**Consultation Response from Alan Smith,
KC Waste Strategy (Refuse & Recycling)**

2025/91531 land off, Leeds Road, Heckmondwike, WF16 9DB

Demolition of existing semi-detached houses and associated buildings, and construction of 51 dwellings, including associated access and other associated works

Responding Ref: WPN 25 018

<b>Date:</b> 29.04.2025	<b>Project:</b> Leeds Road, Heckmondwike	
<b>Scale @ A1:</b> 1:500	<b>Drawing Number:</b> 2403-02-001	<b>Revision:</b> -
<b>Drawn By:</b> CC	<b>Drawing Title:</b> MATERIALS PLAN

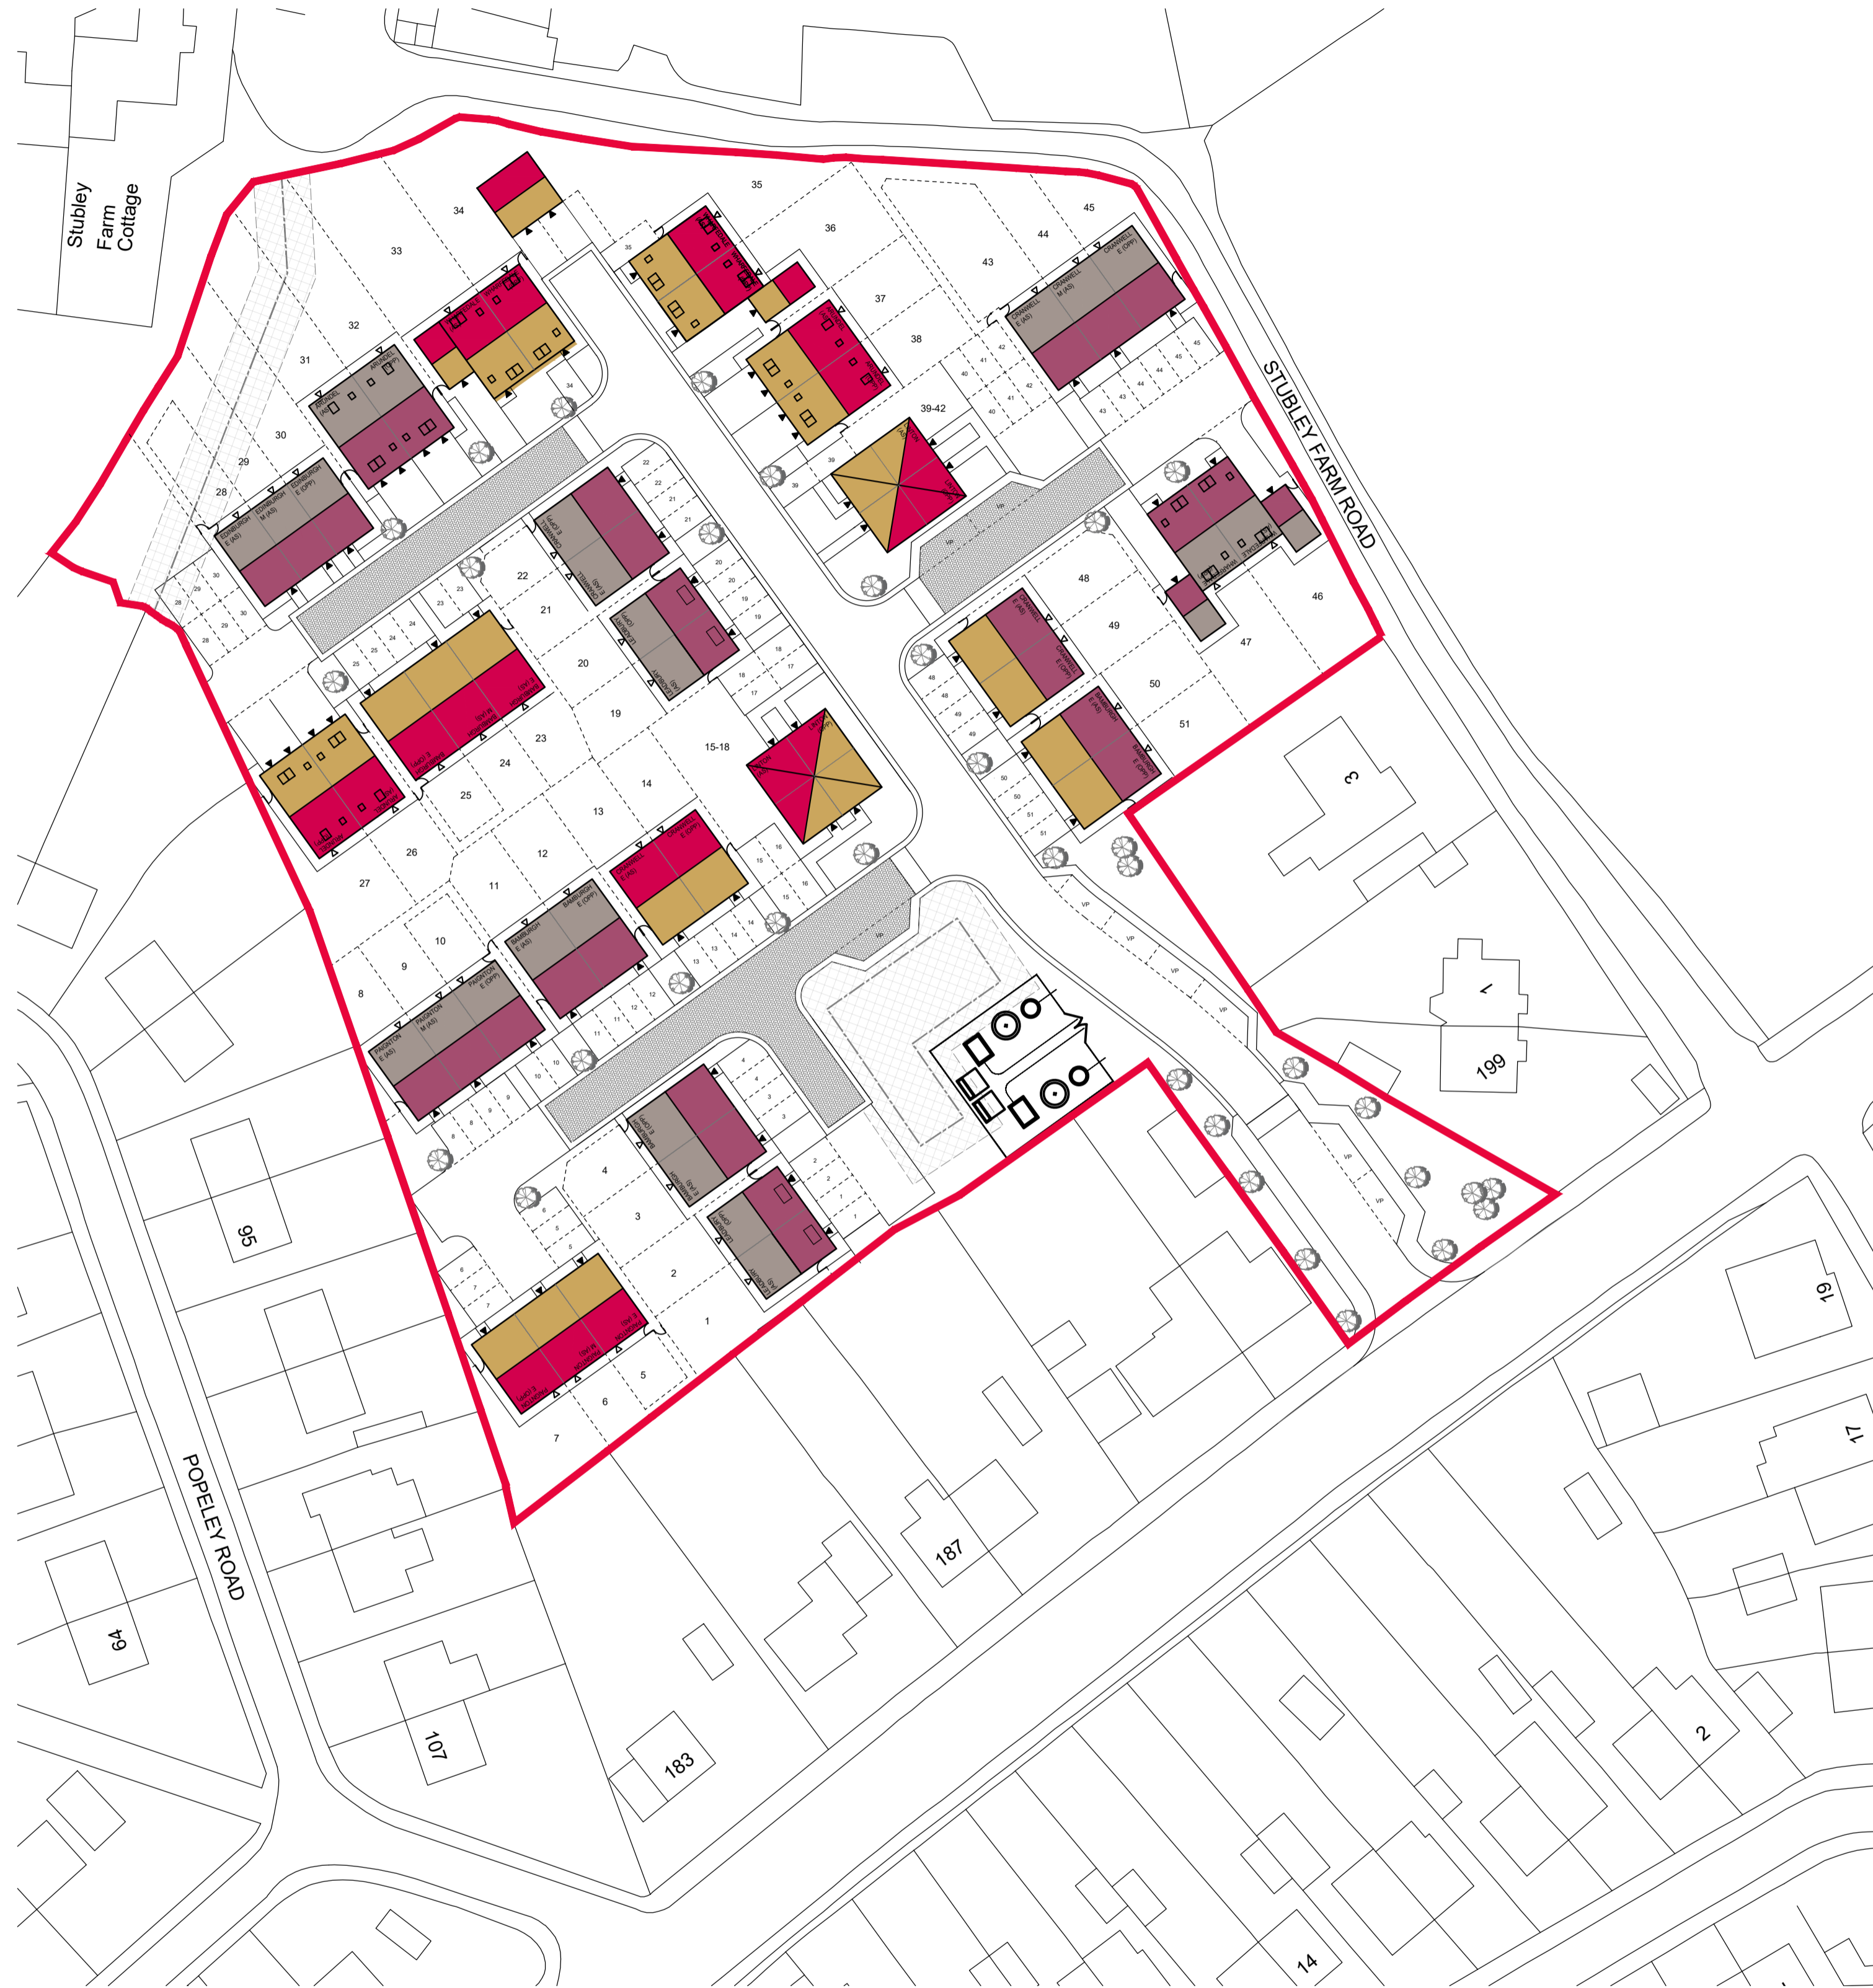
The applicant has submitted Site Plan, "Drawing Number 2403-02-001 Rev A", dated 29/04/2025.

- Plot 1, the distance from the bin storage point to the BCP is over 25m. The issue with this is the resident could opt to keep their bin at the front of their property.

Consideration needs to be given to providing this property with a bin store located at the front of their property. Storage to the front of houses should be screened and avoid wheeled bins being left adjacent to doors and under windows.

- Plots 5 – 9, the distance from the bin storage point to the BCP is over 25m. The issue with this is the residents could opt to keep their bins at the front of their property. Consideration needs to be given to providing these properties with a bin store located at the front of their property. Storage to the front of houses should be screened and avoid wheeled bins being left adjacent to doors and under windows.

- Plots 25 – 29, the distance from the bin storage point to the BCP is over 25m. The issue with this is the residents could opt to keep their bins at the front of their property. One option is to move the BCP for these properties or provide them with a bin store located at the front of their property. Storage to the front of houses should be screened and avoid wheeled bins being left adjacent to doors and under windows.

- Plots 44 – 46, the distance from the bin storage point to the BCP is over 25m. The issue with this is the residents could opt to keep their bins at the front of their property. One option is to move the BCP for these properties or provide them with a bin store located at the front of their property. Storage to the front of houses should be screened and avoid wheeled bins being left adjacent to doors and under windows.
